10090 OTERO AVENUE
Legal: LOT M, VAC W 20.0 FT OF OTERO AVE, BLK B SPRING CREST FIL 2
Area: 115,869 sq ft 2.66 ACRES
Schedule #: 5124004009
Zoning: RR-2 (equivalent RR 2.5)
Owner: MARY AND CHARLES DE LAY
Mailing: 10090 OTERO AVE COLORADO SPRINGS CO, 80920-1537

OWNER: MARY AND CHARLES DE LAY
10090 OTERO AVE CO 80920-1537
Mailing Address: SAME
Mailing Address: SAME
Zoning: RR-2 (Equivalent RR 2.5)
Plan No: RR2022-0014
File No: RR2022-0014
10090 OTERO AVE, BLK B SPRING CREST FIL 2

FEBRUARY 12, 2024

SITE PLAN

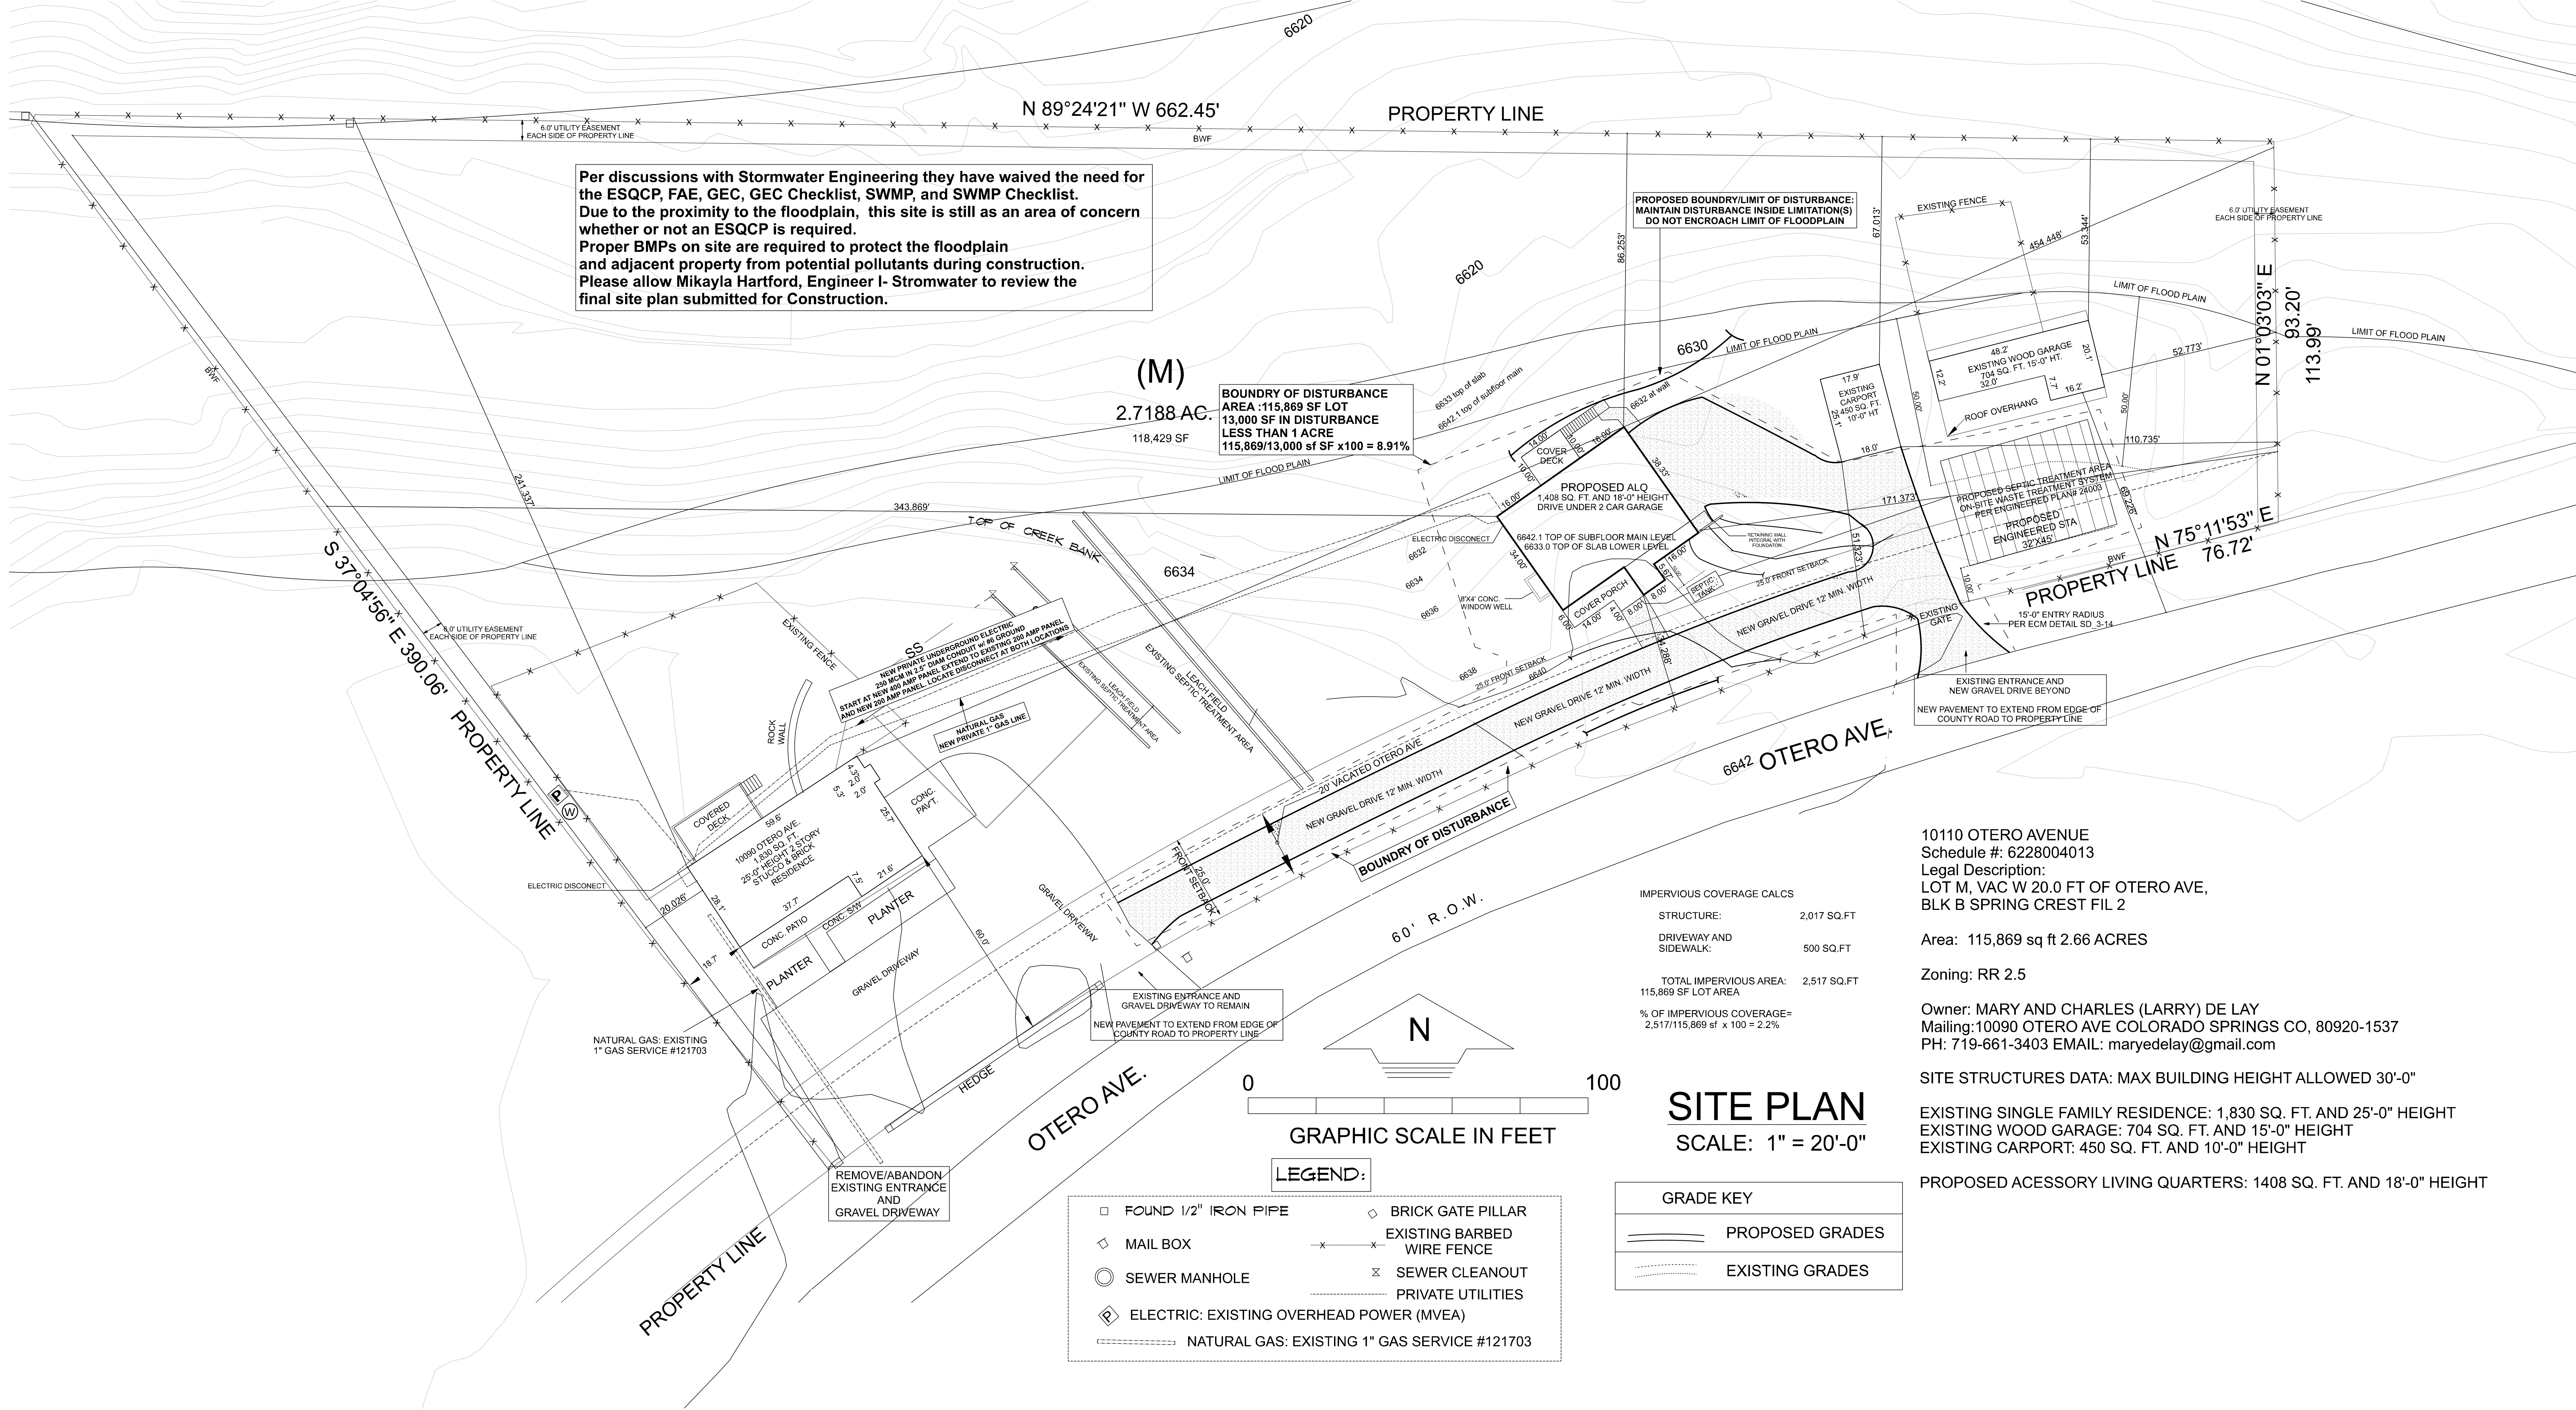
Add note:
Due to the site's proximity to the floodplain, the site is in a sensitive area and will require an ESQCP. A standalone CDR will be required to be approved prior to Building Permit issuance. The following documents will be required with the CDR: Drainage Report, ESQCP, FAE, GEC Plan, GEC Checklist, PBMP Applicability Form, SWMP, and SWMP Checklist.

Add easements to the site plan. Per the plat, all lot lines not adjacent to streets shall have a 12" utility easement 6' on each side of lot lines.
Add note stating maximum height is 30'

The proposed limits of disturbance are encroaching into the floodplain. Please contact Keith Curtis, floodplain administrator, 719-327-2898. E: keith@pprbd.org, regarding the need for a floodplain development permit and any other requirements. Please also refer to EPC stormwater engineers comments regarding additional stormwater requirements due to developments proximity to the floodplain.

adjust limits of disturbance line to encompass all proposed development.

Are these structures existing? Clarify.

What is Proposed STA? Is this a leach field. Please clarify.

Include the driveway connection to Otero Ave in the limits of disturbance.

please identify radius of 15' min at the driveway per ECM detail SD_3-14

Please identify which structures are existing and which are proposed

Please clean up leach field labeling and add clarification as needed.

Please include gravel drive in limits of disturbance

- Add owner's telephone number and email address
- Correct the property tax schedule number
- Correct the zoning to RR-2.5
- Complete the legal description
- Provide the floor area and height of each structure, the setback of all building footprints dimensioned from all property lines.
- Provide explanation of Engineered STA
- Show location of all existing and proposed utility lines and associated infrastructure
- What is BWF?
